**Our ref:** RA/2025/148633/01-L01  
**Your ref:** 2025/91184

**Date:** 20 August 2025

**ERECTION OF TWO STOREY INDUSTRIAL UNIT (USE CLASS E(G)(III)), WITH ASSOCIATED CAR PARK, SERVICE AREA AND OTHER ASSOCIATED WORKS LAND OFF BRETTON STREET, SAVILE TOWN, DEWSBURY, WF12 9BZ**

| TITLE | Drainage Strategy | | | | |

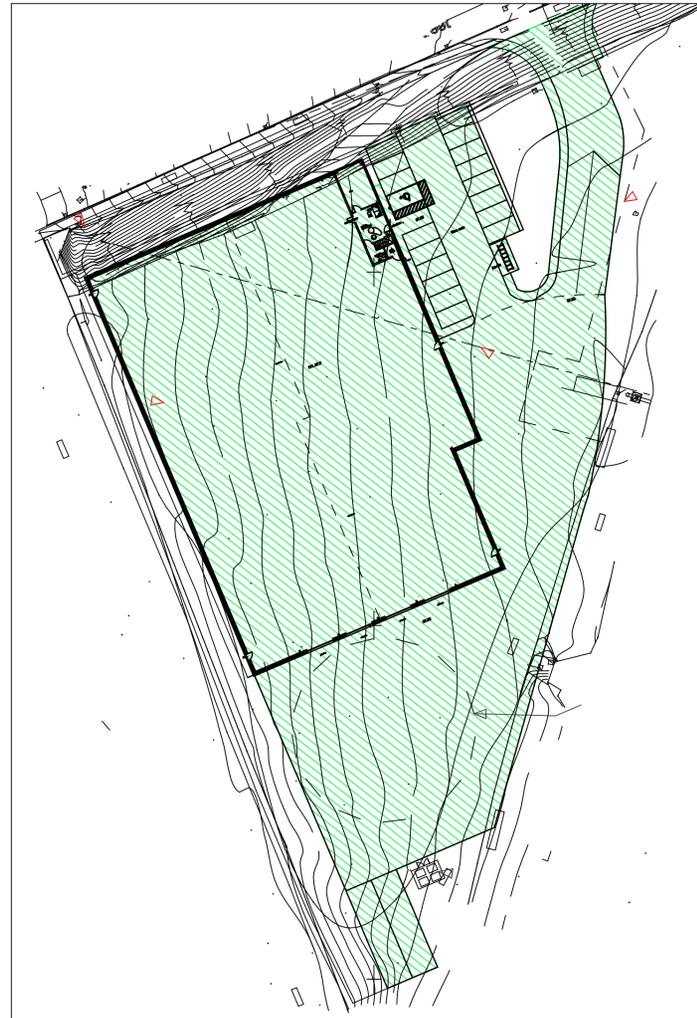
We have no comments to make regarding foul drainage, other than to highlight that the application form states foul effluent will be discharged to mains but the Drainage Strategy (drawing number KS826/D01 Rev P1) states "*Foul will be treated on site and discharge into the Calder and Hebble navigation subject to approval.*" The LPA may wish to clarify the situation.
